DISPLAY THIS CARD ON PRINCIPAL FRONTAGE OF WORK

Job ID: 2012-07-4480-ALTCOMM

has permission to Construct 2nd means of egress

PROJECT NAME: THE CHILDREN'S CENTER - EGRESS STAIRS AND DORMER

A-SITE

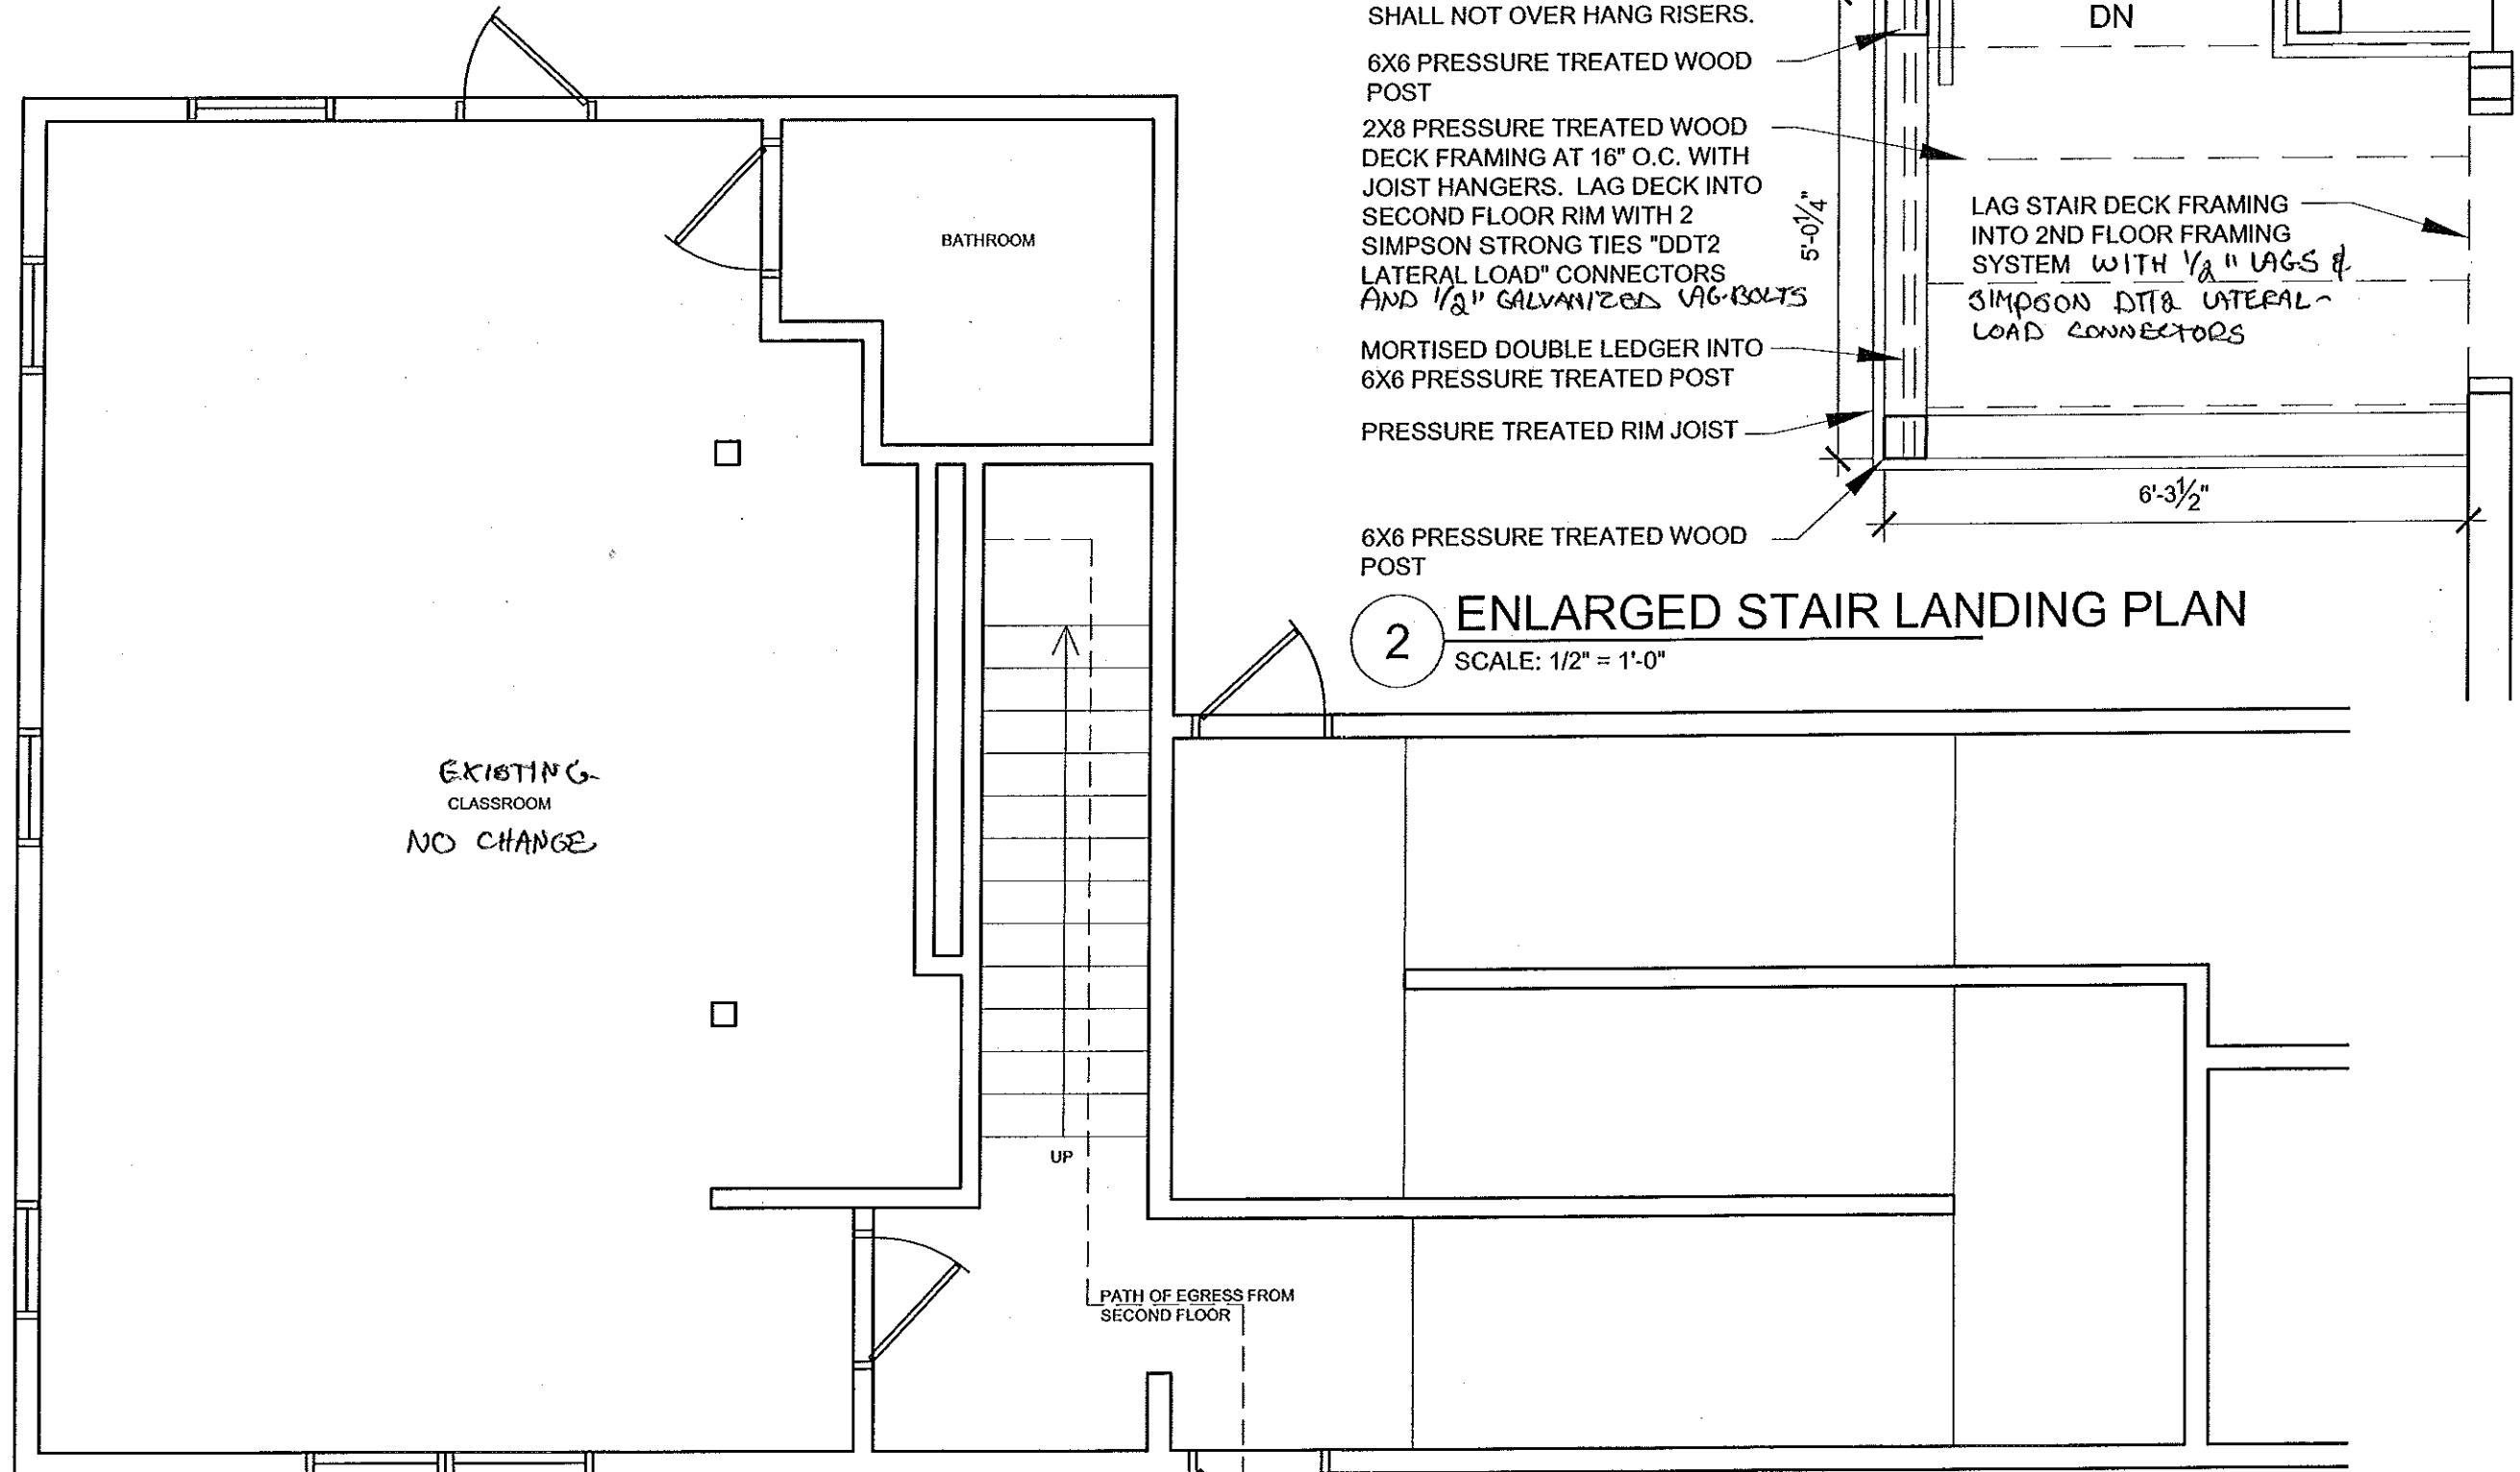
1. All construction shall comply with City Code Chapter 10. The occupancy shall comply with City Code Chapter 10 upon inspection.
2. Minimum tread depth is 11 inches.

2 Dormer Framing Plan
 SCALE: 1/4" = 1'-0"

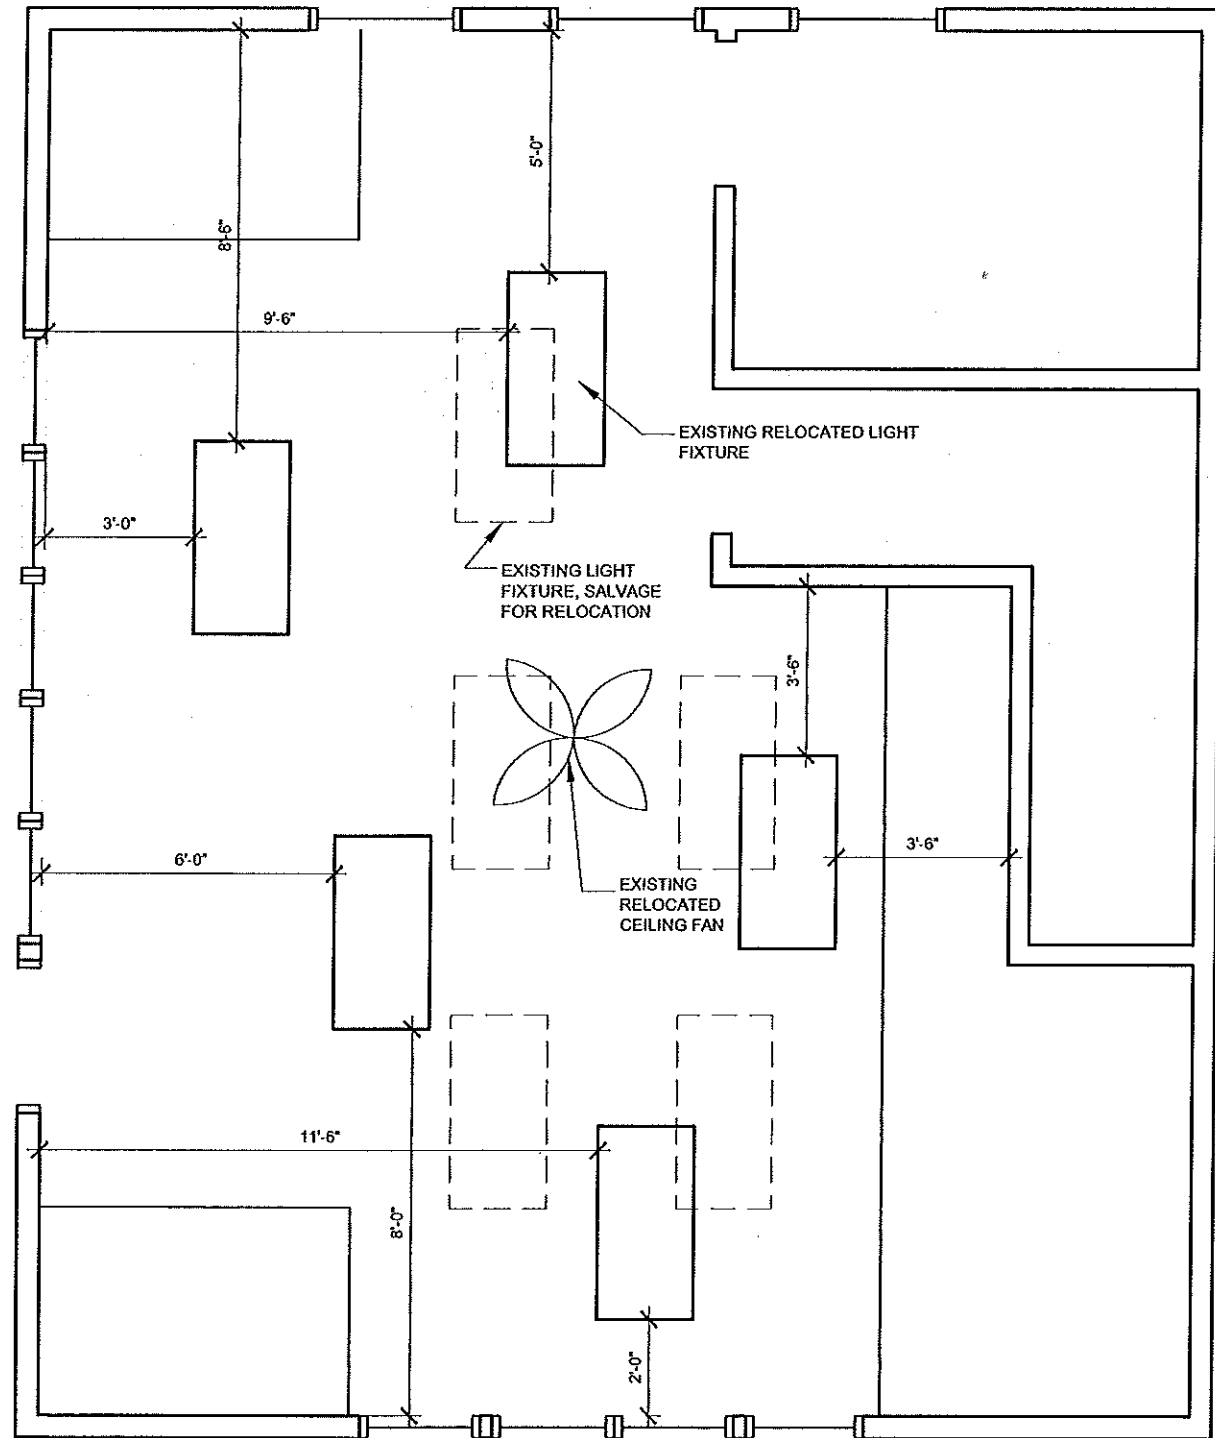
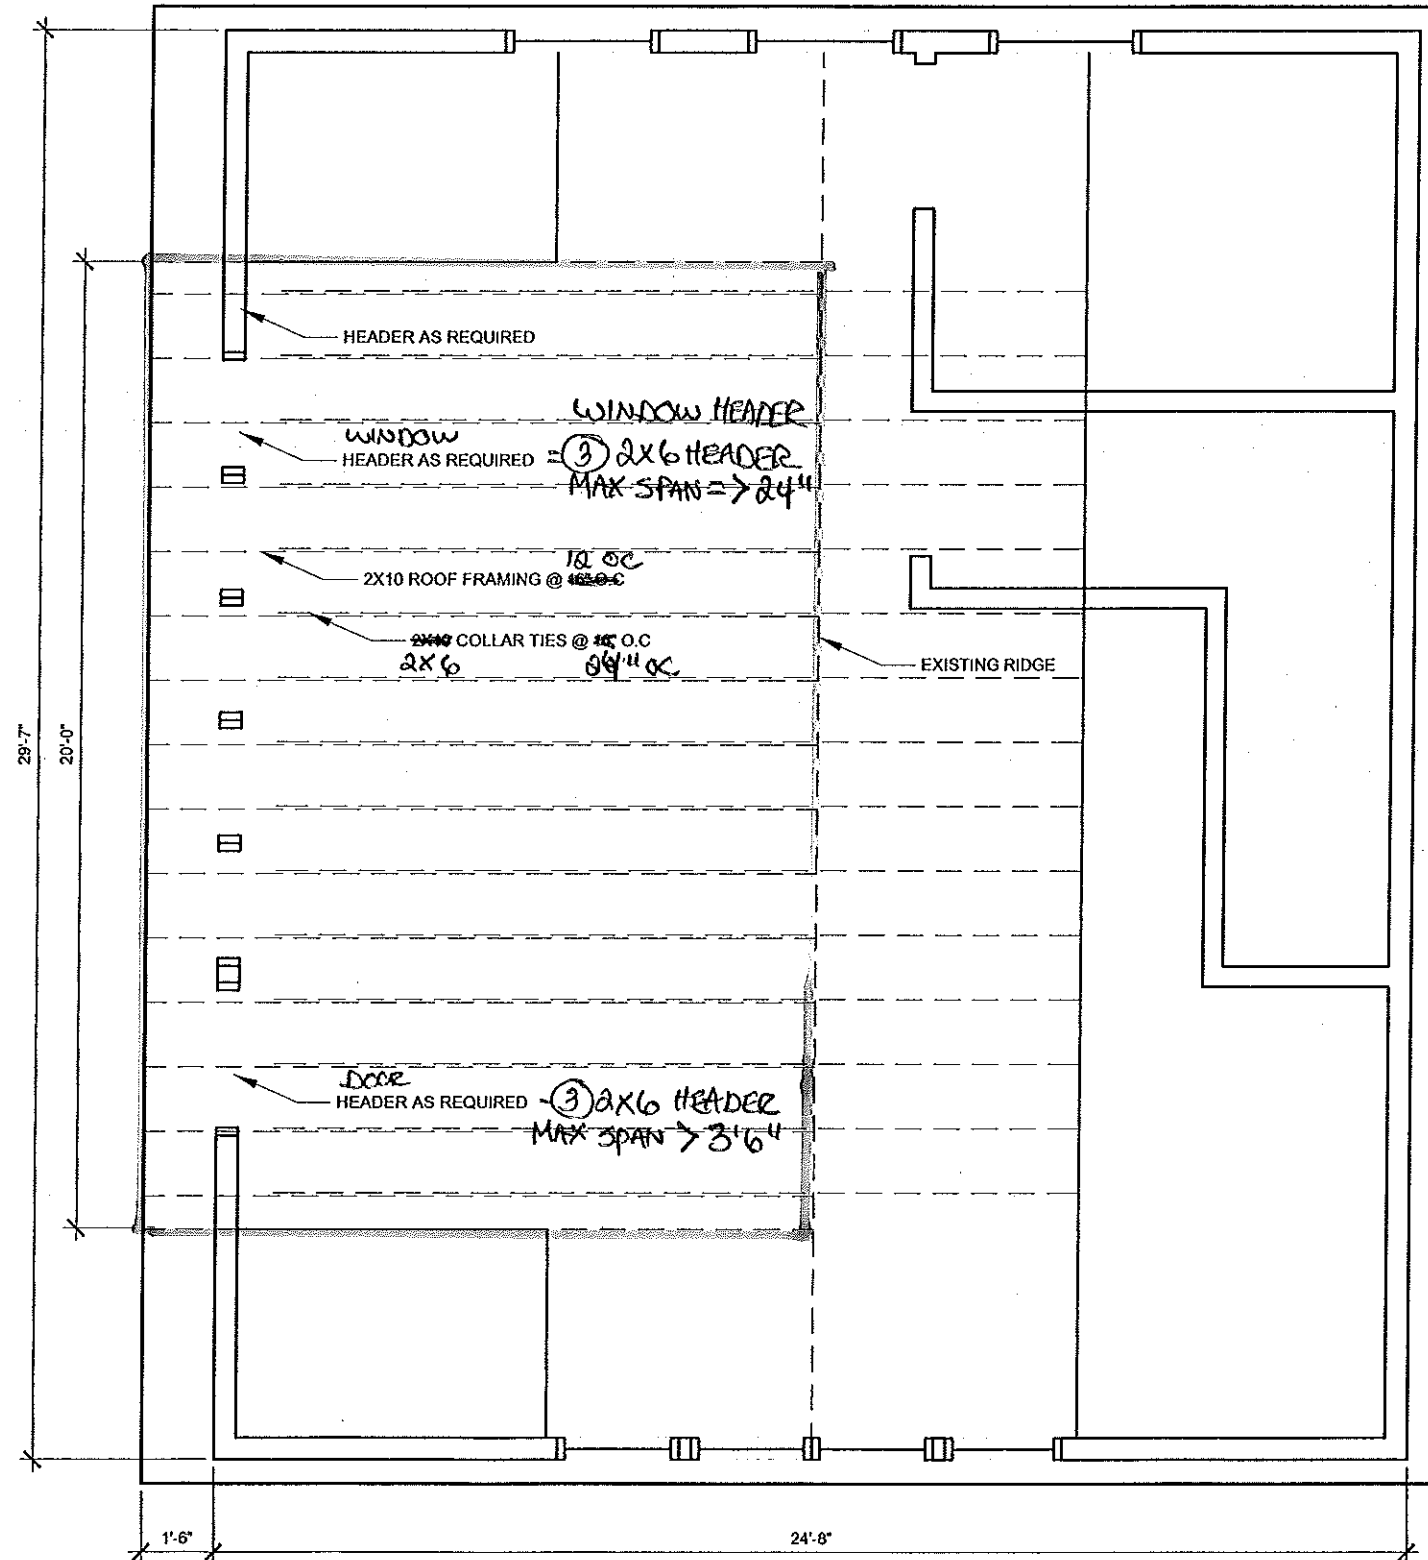
1. Separate permits are required for any electrical, plumbing, sprinkler, fire alarm HVAC systems, heating appliances, commercial hood exhaust systems and fuel tanks. Separate plans may need to be submitted for approval as a part of this process.
2. Application approval based upon information provided by the applicant or design professional. Any deviation from approved plans requires separate review and approval prior to work.
3. Guards must be 42 inches in height with openings less than 4 inches. Graspable rails must be installed on both sides of the stair guard at 34" to 38".
4. **The dormer rafters must be 2" x 12"-s 12" oc.**
